CLEVE HILL SOLAR PARK

AMENDMENT APPLICATION ENVIRONMENTAL STATEMENT CLARIFICATION NOTE

November 2019
Revision A

CLARIFICATION NOTE - REMOVAL OF NORTHERN ACCESS ROUTE OPTION

Site Access Options
Figure 5.10

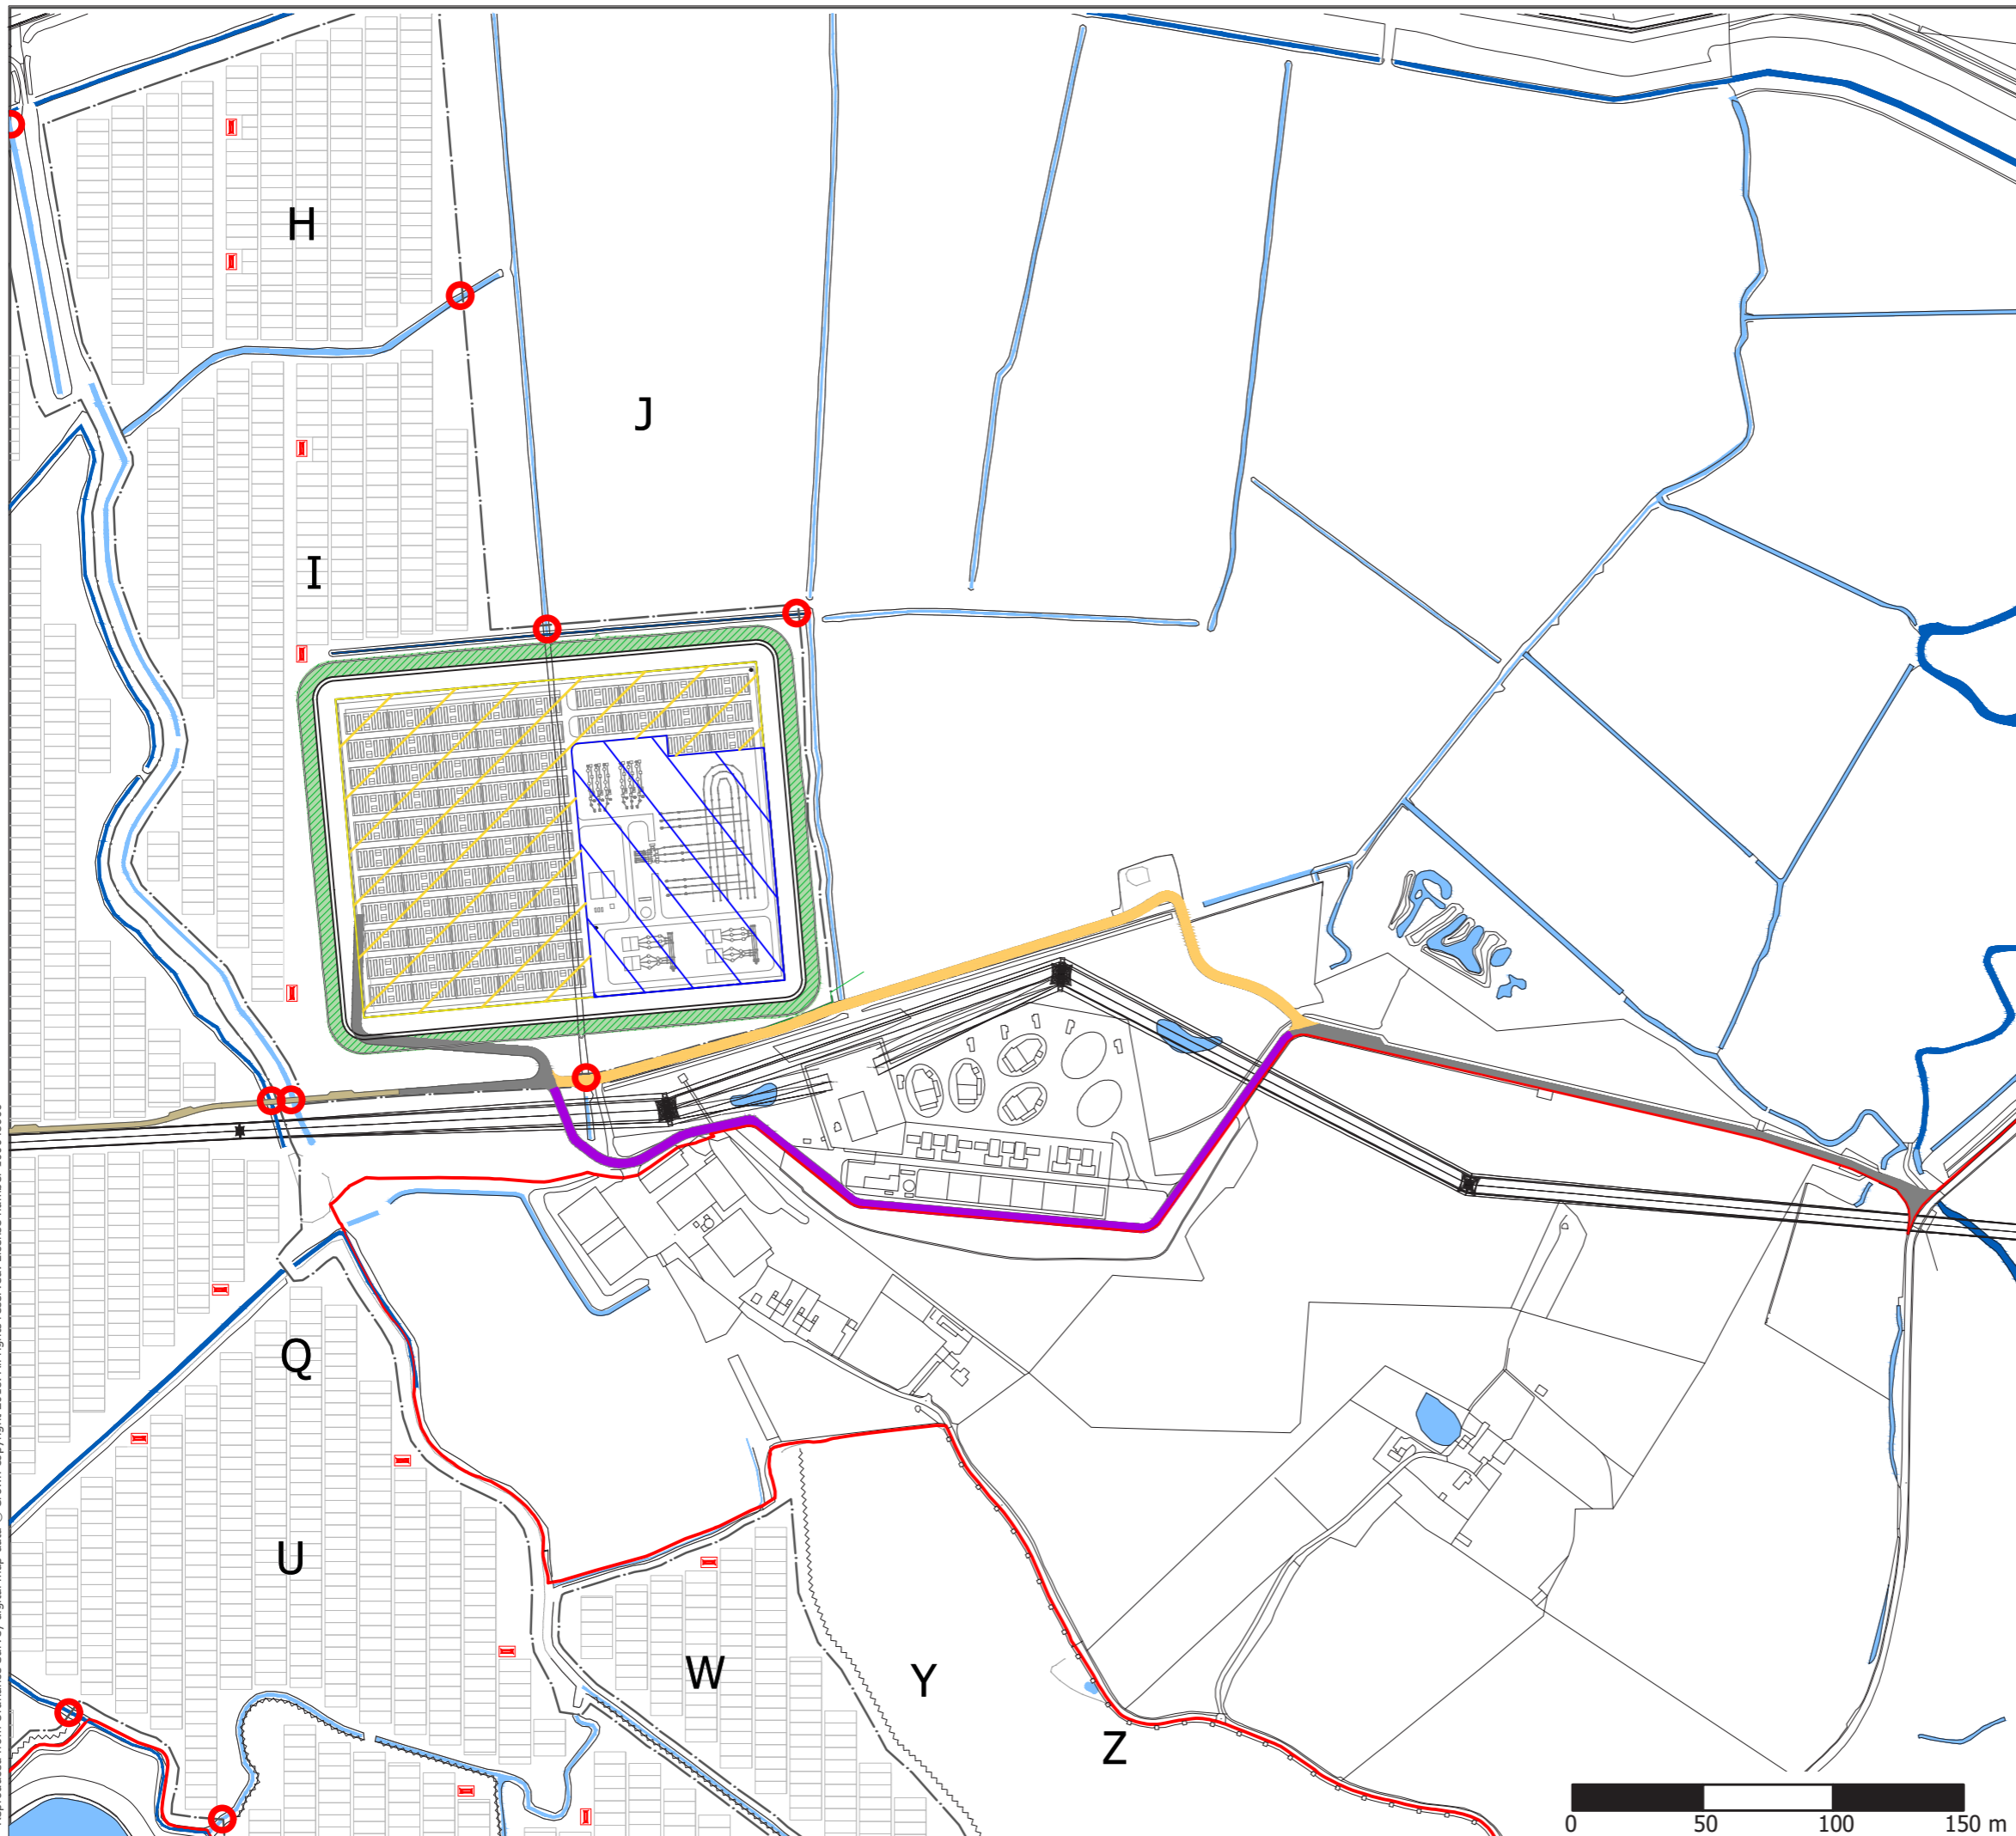
- The northern route; and
 - The southern route.
2. The Applicant has taken the decision to remove the proposed “northern route” option from the Development. The existing farm track which formed part of the northern route is retained, shown yellow and marked D-D on the revised Streets and Access Plan. This existing track connects the existing access from Seasalter Road to the proposed Habitat Management Area.

3. The decision to remove the northern route has been taken in response to consultation and successful negotiations with landowners in respect of the southern route. There is universal support from consultees, including statutory nature conservation bodies (SNCBs), local authorities and landowners for the use of the southern route. The Applicant's intention to make this decision has been made clear during the examination of this application and all interested parties have had opportunity to comment on it. There have been no significant concerns raised against the use of the southern route, and common support for the removal of the northern route.

6. The ES does not require to be updated as a result of the removal of the northern access option. The effects of the Development utilising the southern access option would be the same as, or of a lower level than, that assessed in the ES.
